Briefing Note

REF: P22-1080 Land North of Camp Road, Heyford Park **DATE:** 28/04/2022

- 1.1 Planning application 21/04289/OUT has been submitted to Cherwell District Council relating to the proposed development of 230 dwellings to the north of Camp Road and west of Chilgrove Drive, east of Heyford Park, Oxfordshire. The project is EIA development, and an Environmental Statement (ES) accompanies the planning application. This Briefing Note was commissioned by Dorchester Living Limited as an independent audit of that work and presents the findings of a high-level review of ES Appendix 8.1 Landscape and Visual Impact Assessment ('the LVIA', prepared by Tyler Grange (TG report No. 13464_R04a_AW dated 23rd December 2021)).
- 1.2 The LVIA comprises 5 sections (Introduction and Scope; Baseline Appraisal; The Proposals and Planning Context; Assessment of Effects; and Conclusion) and is supported by Appendices and Plans.

Visualisation Type: Type 1
Image Enlargement: 100%
Page Size: A3

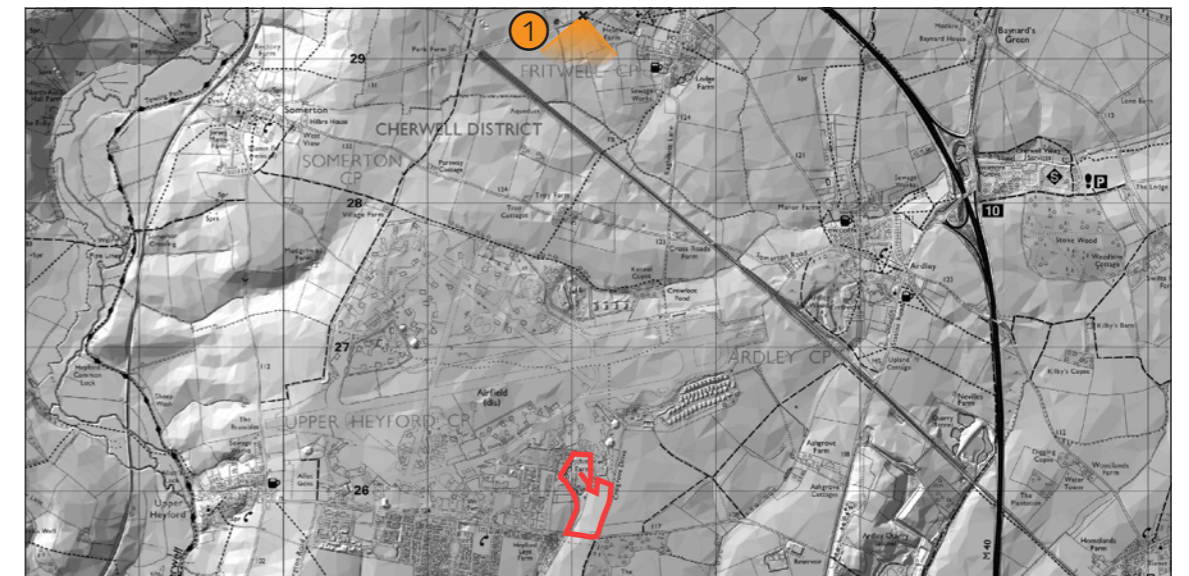
Photosheet	Comments
1	Approximate location of site/development not indicated; not in accordance with TGN06/19.
2	Type 1 and context views looking in wrong direction, aligned with centreline of railway tracks looking NW (the Type 1 view is cropped looking NW to NNW). Site lies WNW to left of view. Viewpoint on bridge further to east would have provided a more open view toward site/be more representative. Approximate location of site/development not indicated; not in accordance with TGN06/19.

Visualisation Type: Type 1
Image Enlargement: 100%
Page Size: A3

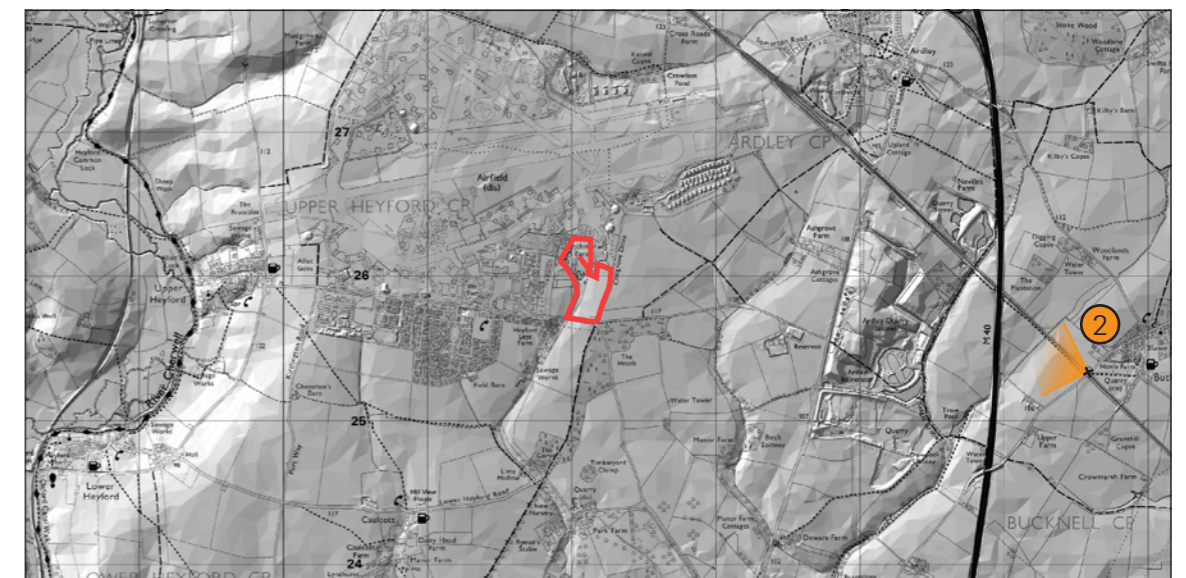
Photosheet	Comments
3	<p>Viewpoint incorrectly located to east, not west of woodland belt; Oxfordshire Definitive Map (and Ordnance Survey map) shows PROW 289/1/20 (Aves Ditch/Claud Duval Way) along western edge of woodland belt.</p> <p>Viewpoint on PROW to the west of the woodland belt more likely to have open view toward site/would not be screened by the woodland belt (see Photoview 5).</p> <p>Approximate location of site/development not indicated; not in accordance with TGN06/19.</p>
4	<p>Annotation on Type 1 and context views appears to apply to eastern boundary of site only – the actual extent of site (northern section) extends closer to the hardened aircraft shelters visible (c.9m height) to the NW (in the right-hand part) of the context view.</p> <p>Extent of site shown incorrectly, implying that the site is smaller than it actually is/occupies a narrower field of view.</p> <p>Location and extent of proposed built form not indicated.</p>

Date: December 2021
Status: Planning
View: 10

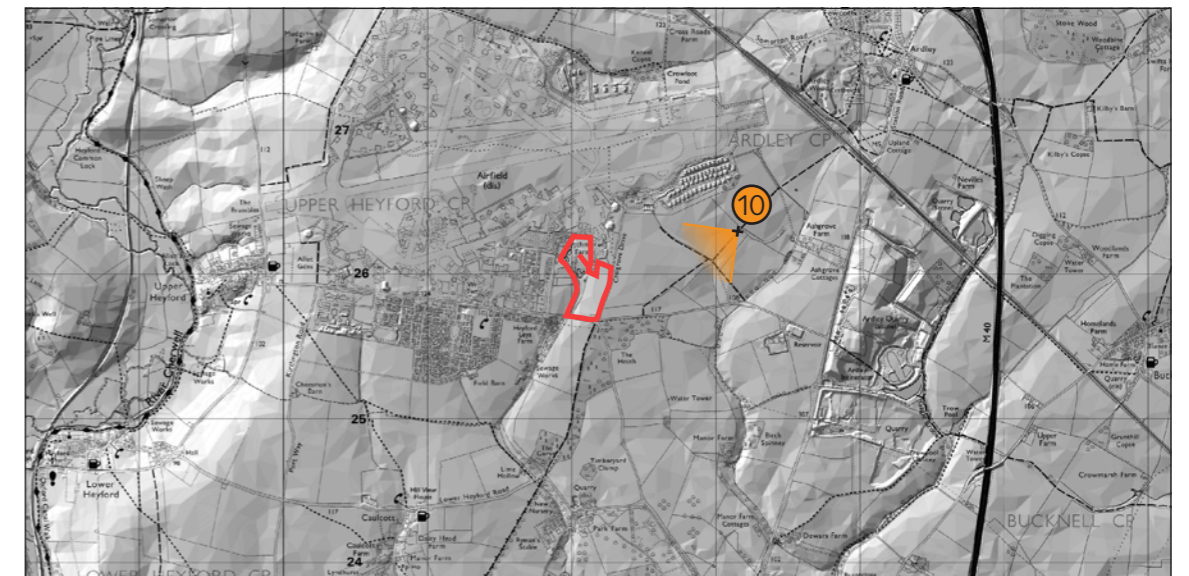
10	<p>Annotation on Type 1 and context views appears to apply to eastern boundary of site only – the actual extent of site (northern section) extends closer to the hardened aircraft shelters visible (c.9m high) to the NW (in the right-hand part) of the context view. The southeast corner lies closer to the road sign (left) than indicated.</p> <p>Extent of site shown incorrectly, implying that the site occupies only about half of the actual width of view than it does in reality.</p> <p>Location and extent of proposed built form not indicated.</p>
